2, Elmer Court,  
Elmer Sands,  
PO22 6JT

16 January 2026

The following is an objection to certain parts of the planning permission **M/98/25/HH** which follows enforcement case **ENF/328/24** following refusal and dismissed appeal of **M/100/24/HH**

06 SIDE (EAST) ELEVATION:

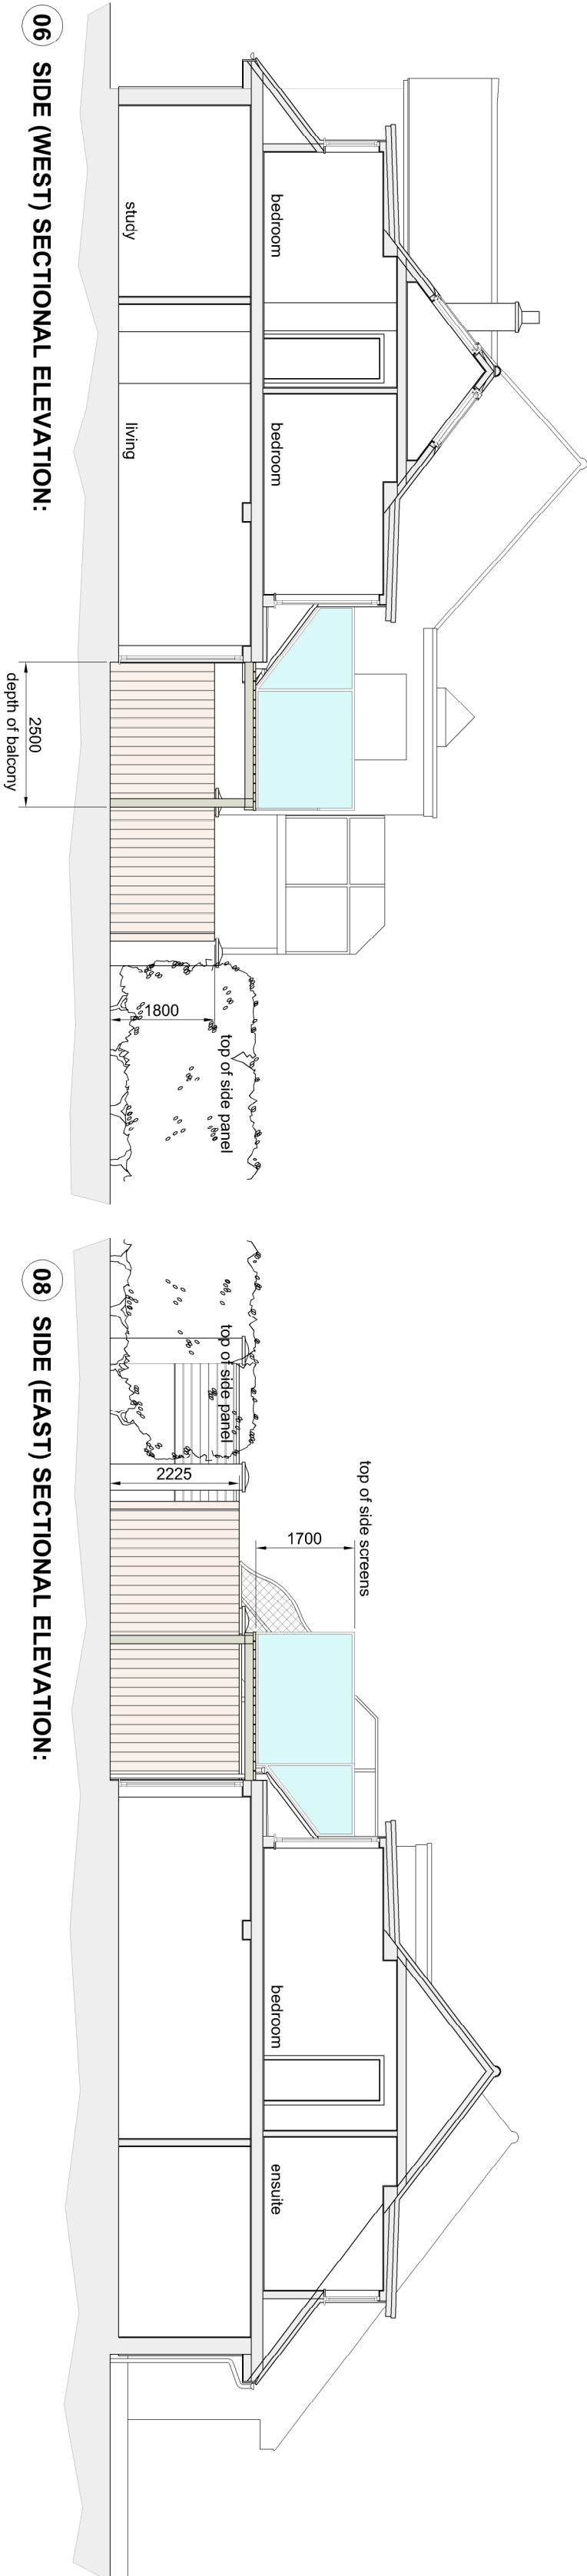
- In the Proposed Plans and Elevations between No.1 and No.2 Elmer Court, the measurement given from the edge of the balcony platform to the actual boundary line (which runs along the centre of the party boundary wall) is actually 250mm not 355mm as shown. The distance from the edge of the balcony platform to the edge of the boundary wall is just 180mm which actually answers the question asked by Arun in their letter of 24<sup>th</sup> December 2025, “*Site Plan - Please add the dimensions from the proposed balcony extension to each site boundary edge*”. These measurements **are actual** as they have been physically taken from the already built unlawful structure to the boundary line/party wall.

In this case the gaps between No.4 The Hard, 1, Elmer Court and 2, Elmer Court are indeed “relatively small”, and is very small at 98cm between No.1 and No.2 and as the balcony is at first floor level it fails the test, “*any extension or alteration at first floor level does not come to within a minimum of one metre of the side boundary*”. The balcony edge is currently just 25cm from the boundary line between 1 and 2 Elmer Court and 18cm from the edge of the boundary wall.

In addition the height, including the substantial metal and opaque glass side screens built on the balcony platform which itself will be on top of a solid wood fence will be 4.50 meters tall built right up to the boundary maintaining the overshadowing and overbearing aspect and sense of enclosure as identified by the Arun Planning officer in their refusal and also identified by the planning Inspector when dismissing the appeal.
